From: Iain Osenton
Sent: 12 August 2019 10:47
To: Caroline Ford
Subject: RE: 19/00248/DISC - Holiday Inn Express, Bicester Gateway Business Park

Reviewing the Landscape management plan, I have no objections with reference to the tree/hedge management. Furthermore the proposal seeks to retain the majority of boundary trees, removing only 1 group (G9).

APPENDIX C – Trees to be Removed / Retained

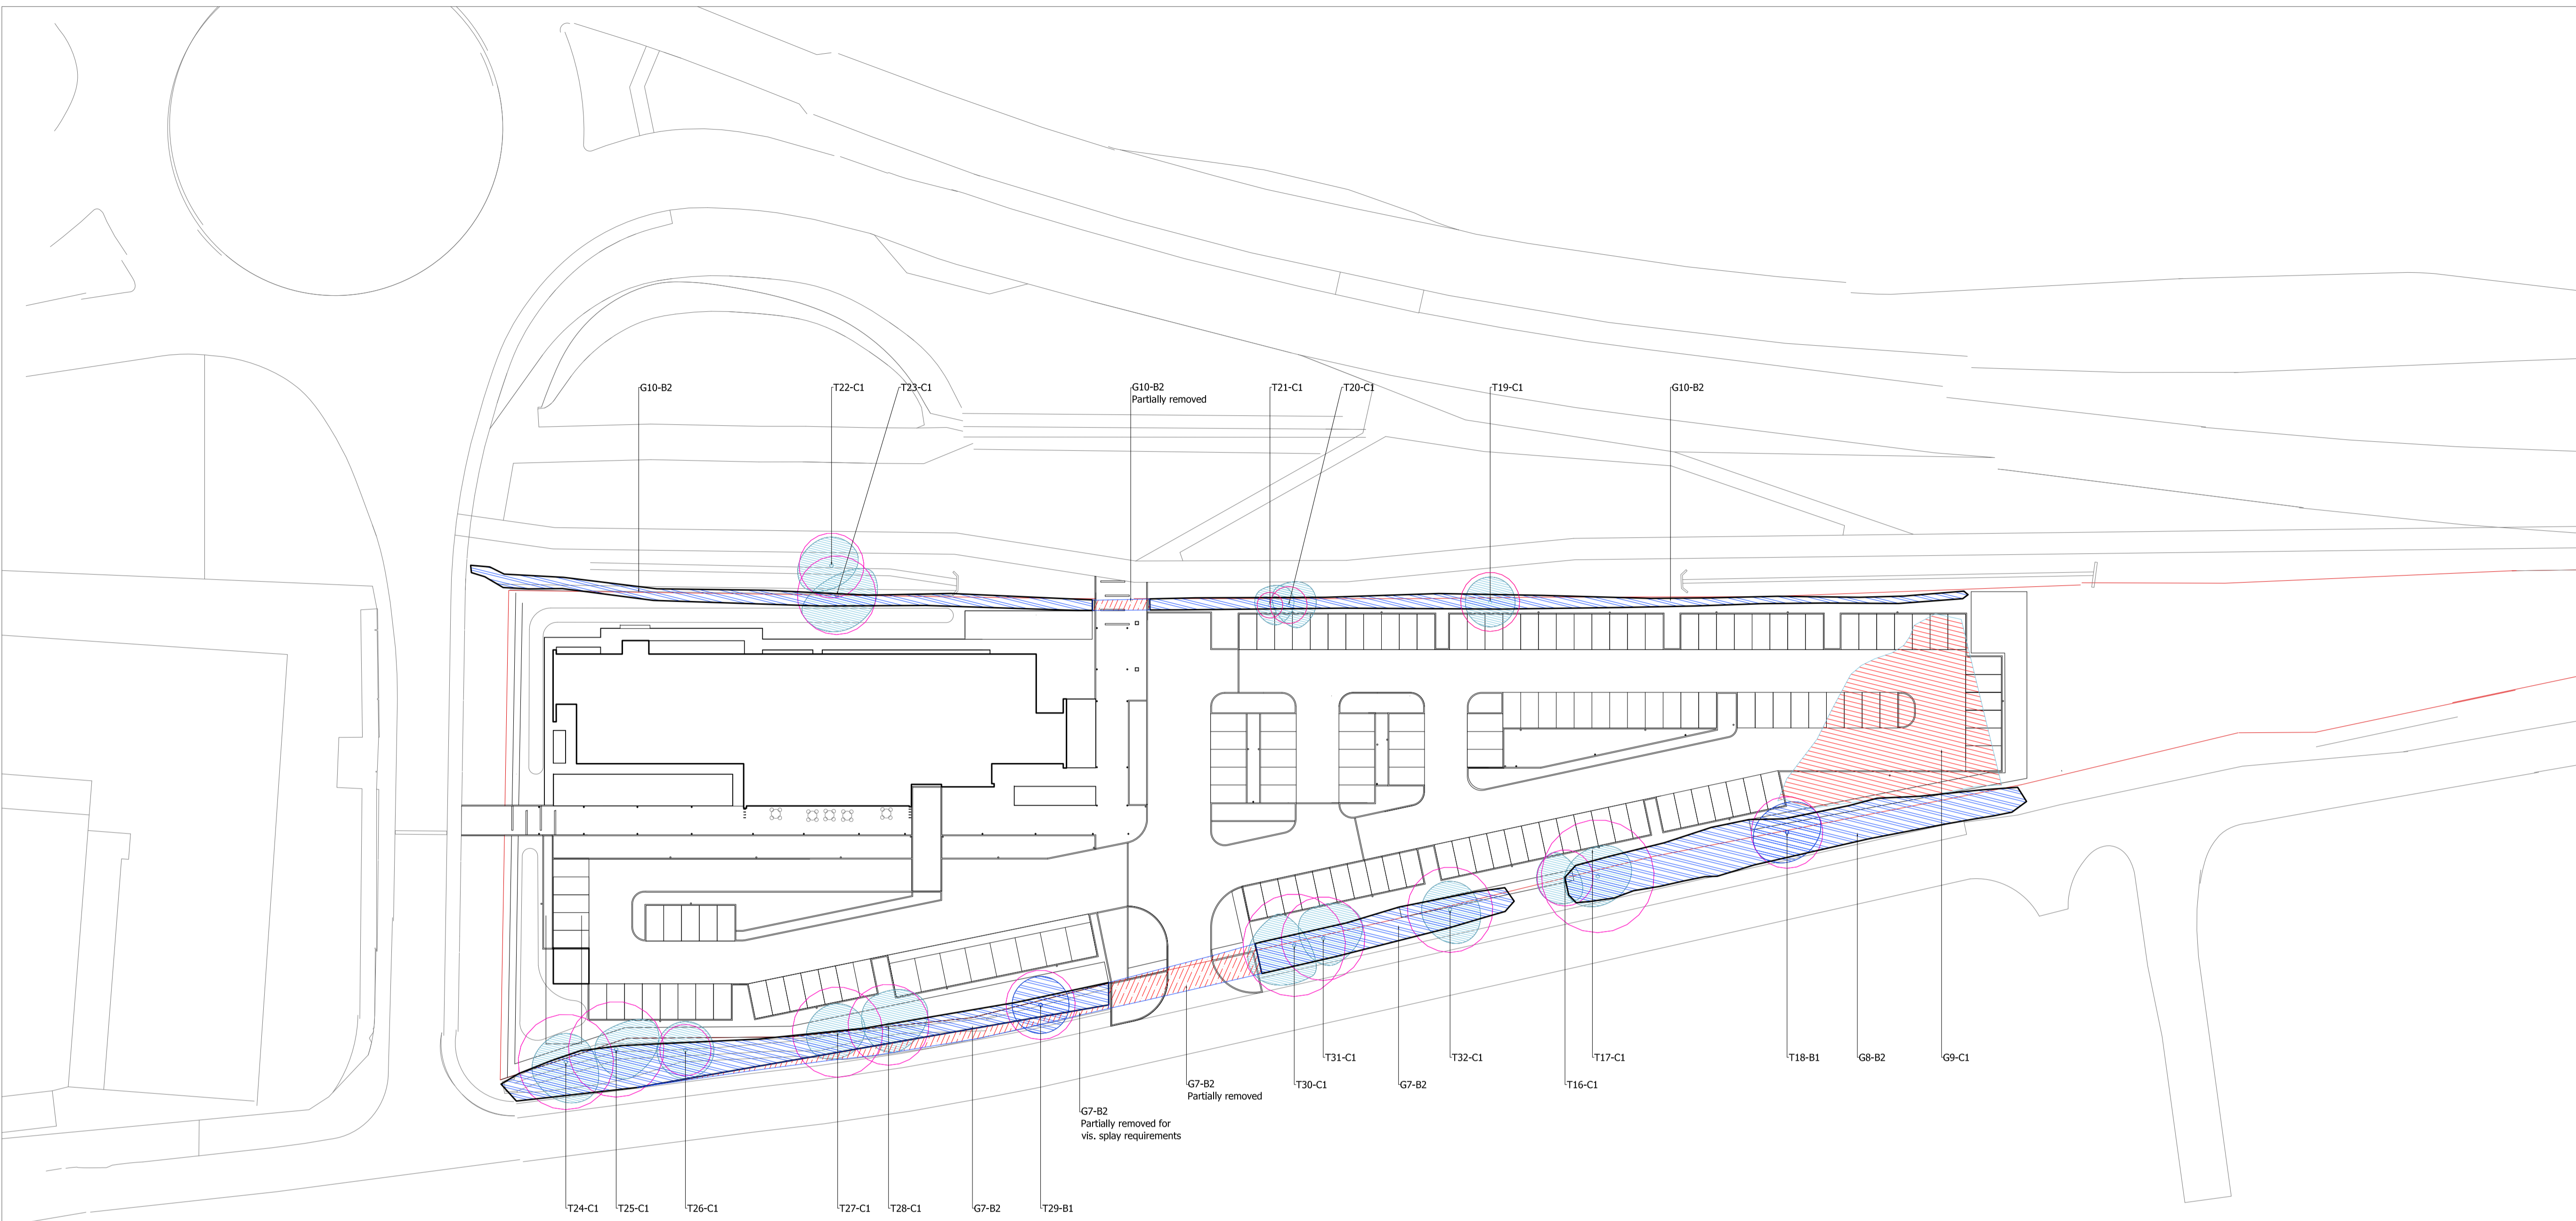
Ensuring protective measures as detailed within the landscape management plans, and previously submitted Arboricultural method statement are followed, I have no concerns for retained trees protection. Could you confirm please if a detailed tree planting plan has been submitted to date, with detail on number of trees, distribution of species throughout the site, and tree pit details?
